From: Chris Flint [REDACTED]
Sent: 13 March 2018 11:30
To: Juan Baeza
Cc: Kelly Lewis
Subject: Re: LU/280/17/PL

Proposed Conversion Elevations

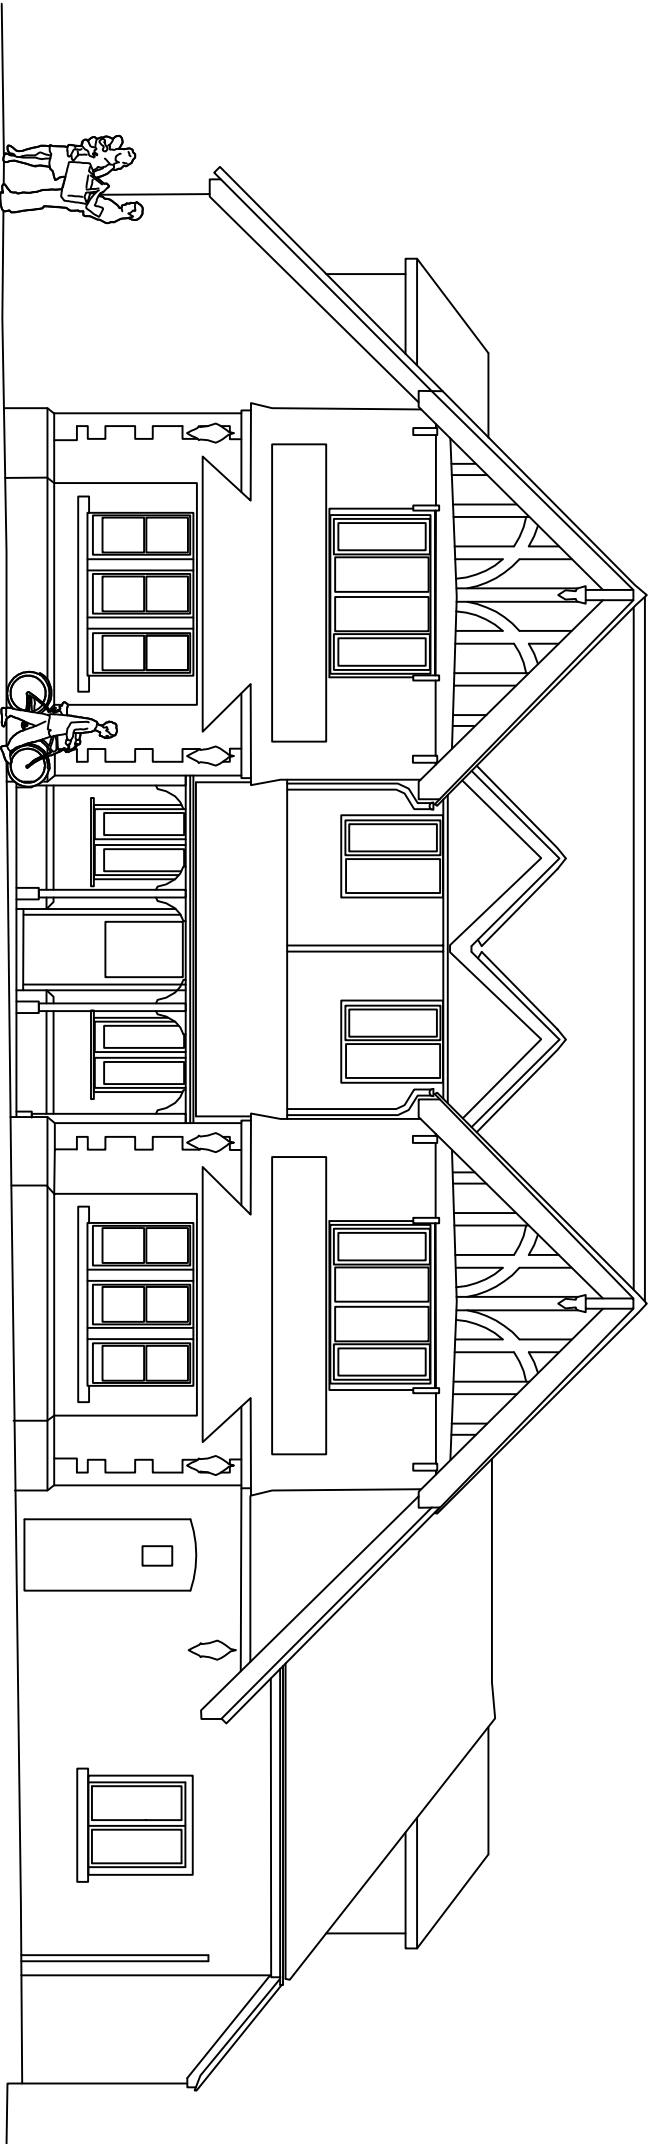
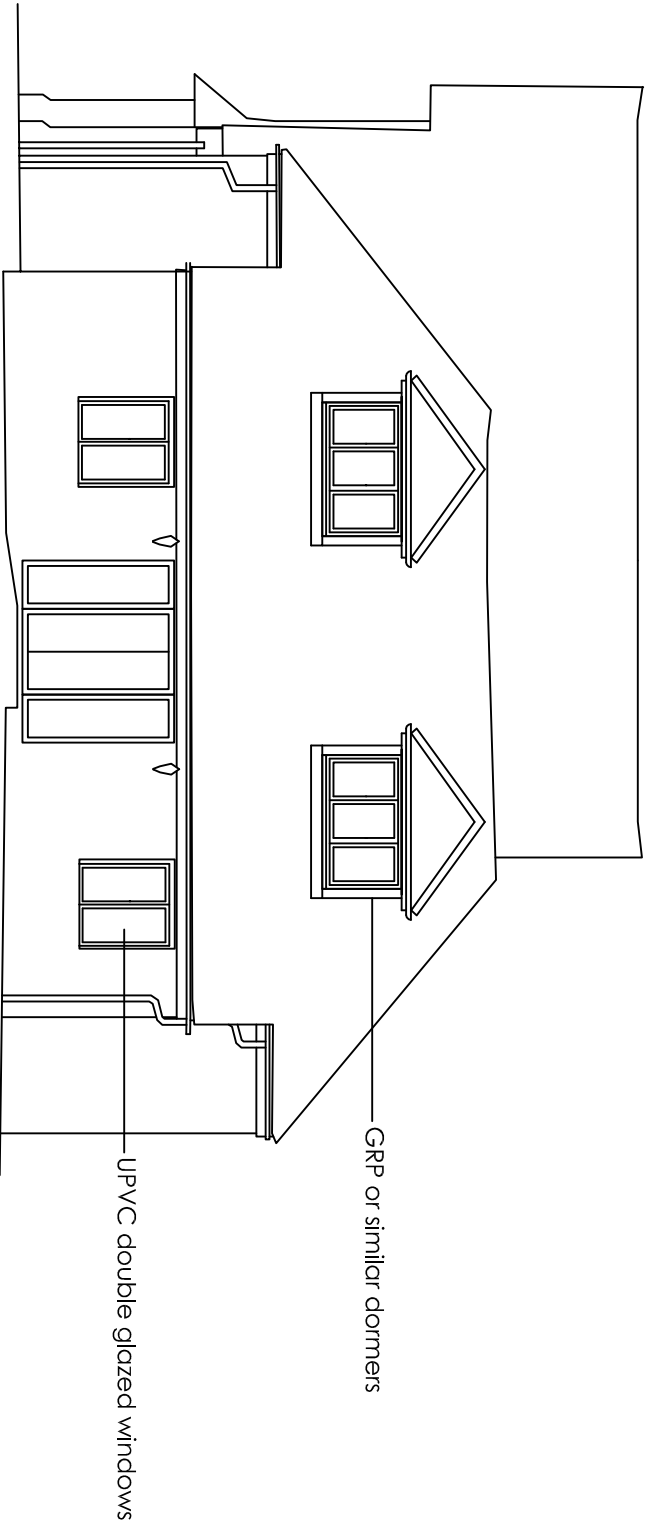
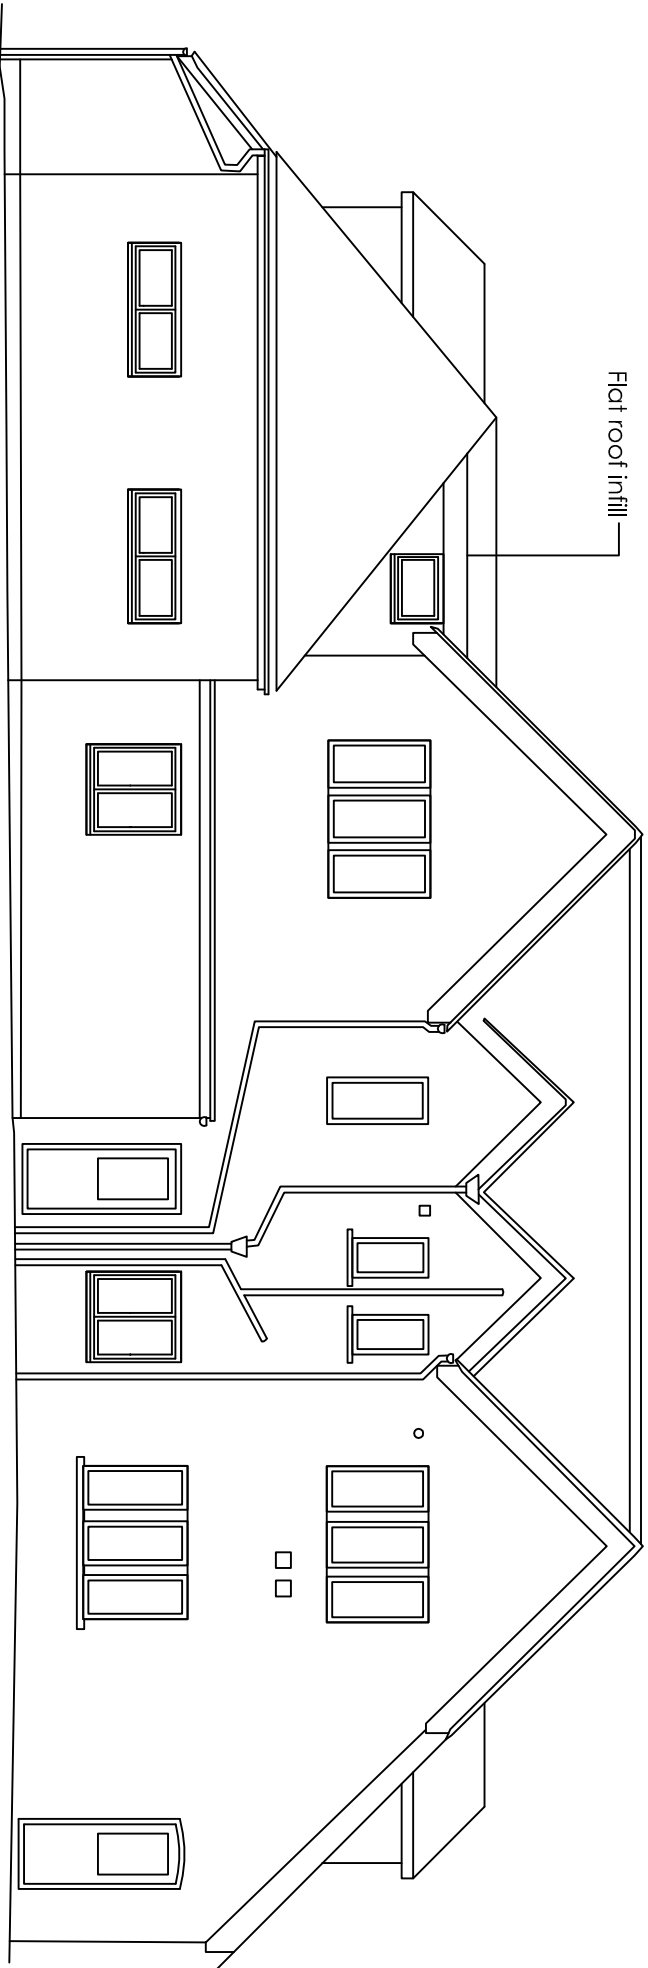
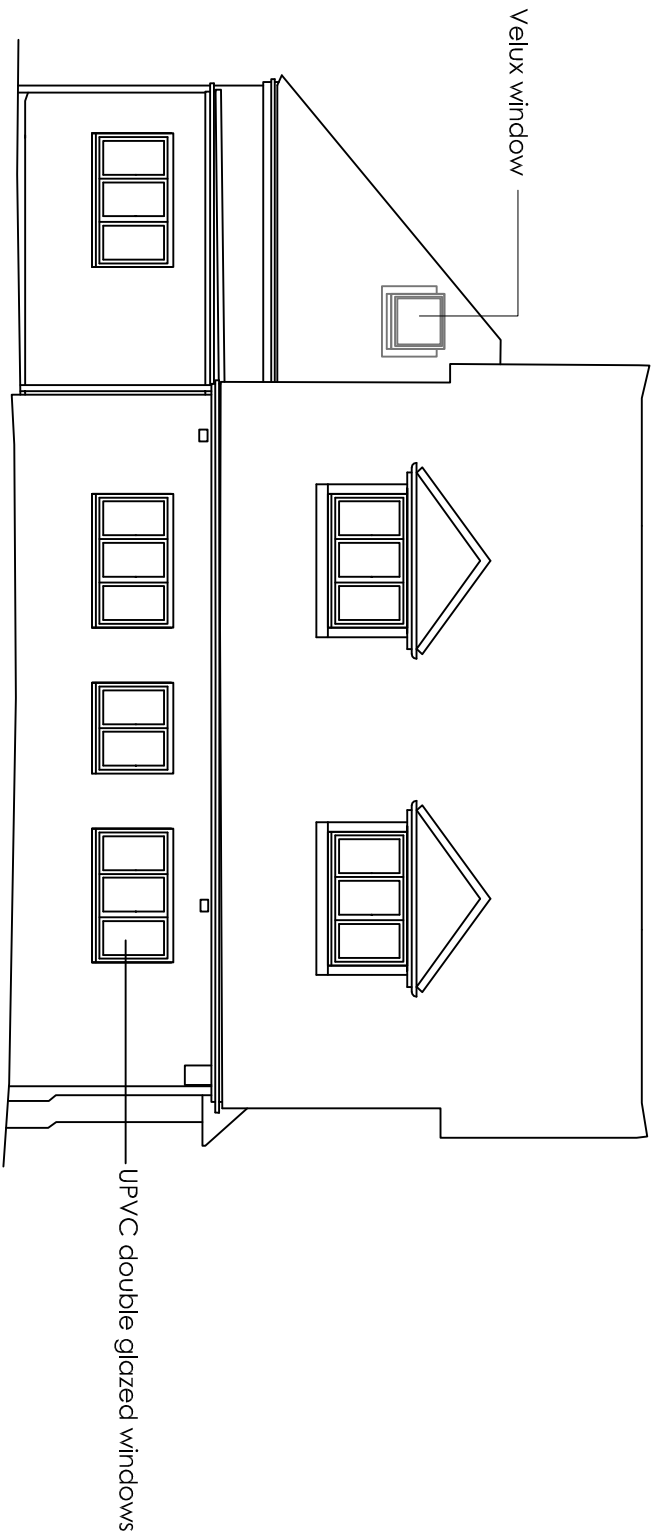
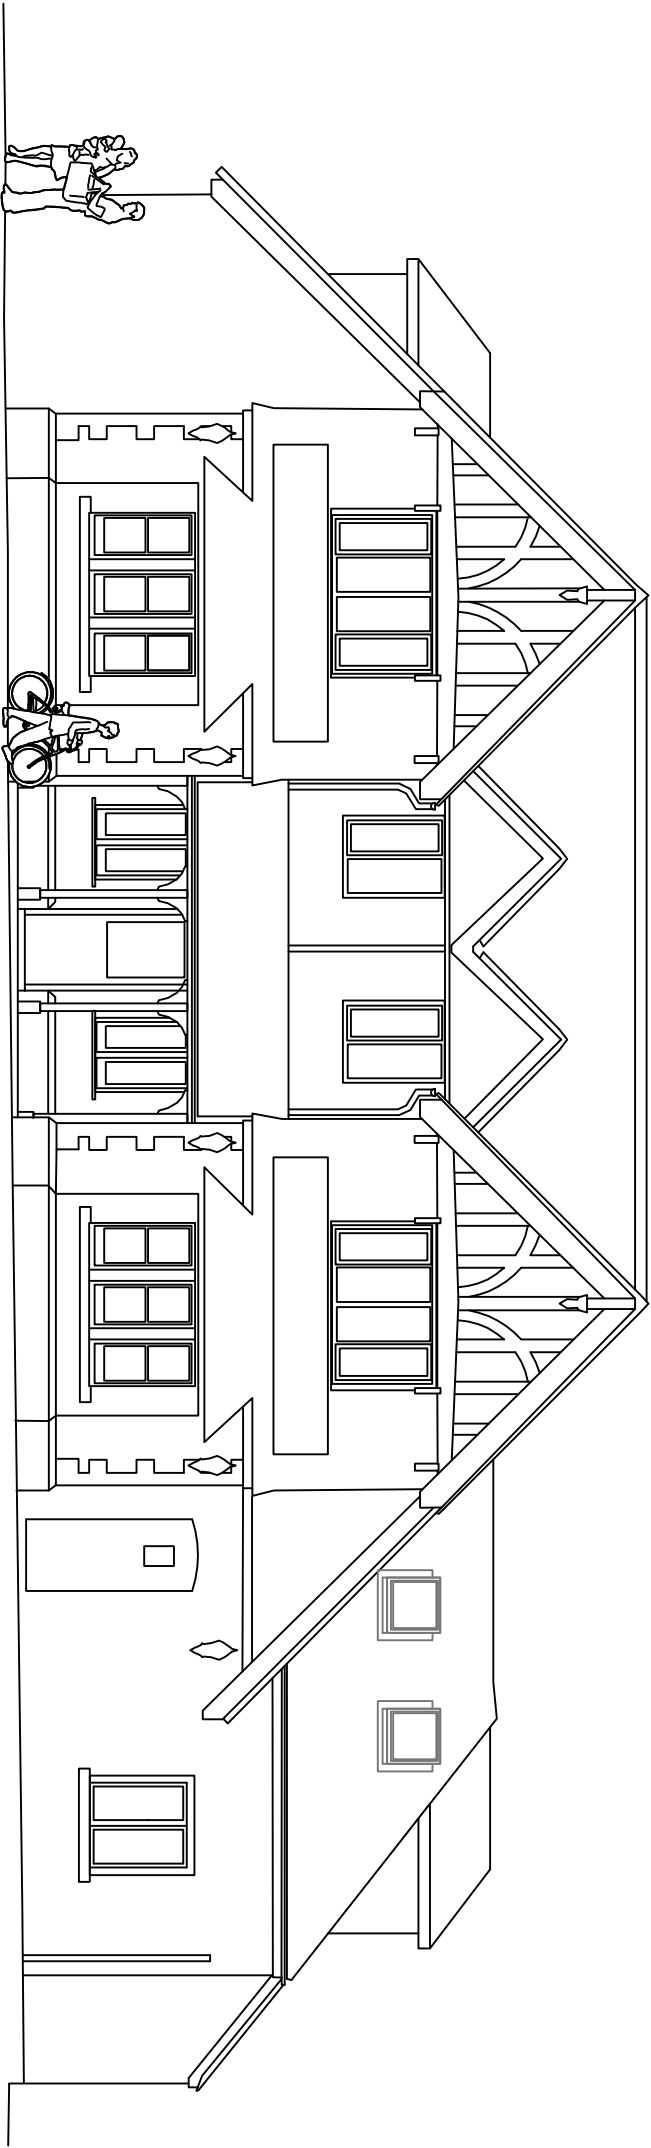
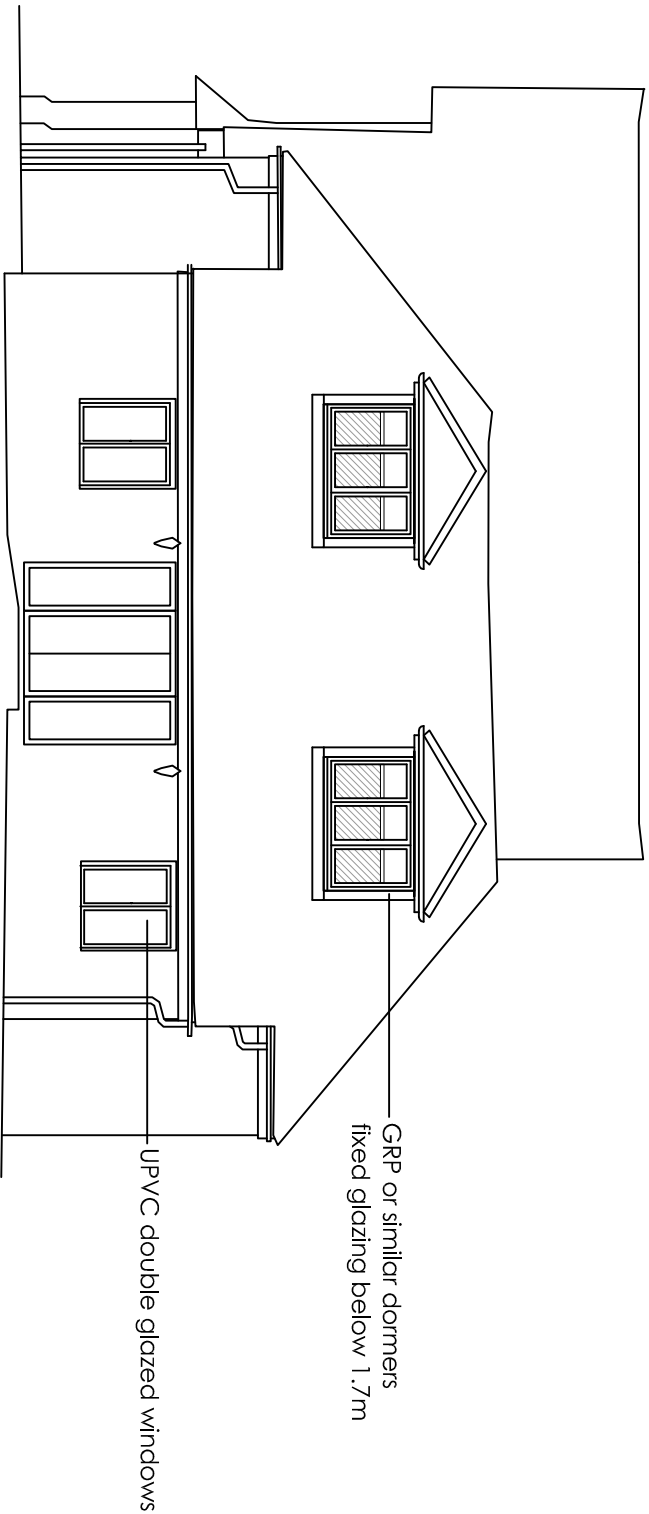
This application is down for tomorrows Development Control Committee. As a matter of urgency I would like confirmation, preferably by way of a cross section drawing, that the two proposed dormers on the northern roof slope will be able to be provided with a section of glass that is non obscure and able to open notwithstanding condition number 3 which states :

‘The two dormer windows on the north elevation of the building shall at all times be glazed with obscured glass and fixed to be permanently non-opening up to 1.7m above ground floor level.

Further to our conversation please find attached amended drawings to show fixed windows to a height of 1.7m on the north elevation dormer we also show a section with a opening fan light above 1.7m we have also added a number of velux windows again non-openable at 1.7m but providing additional light and ventilation.
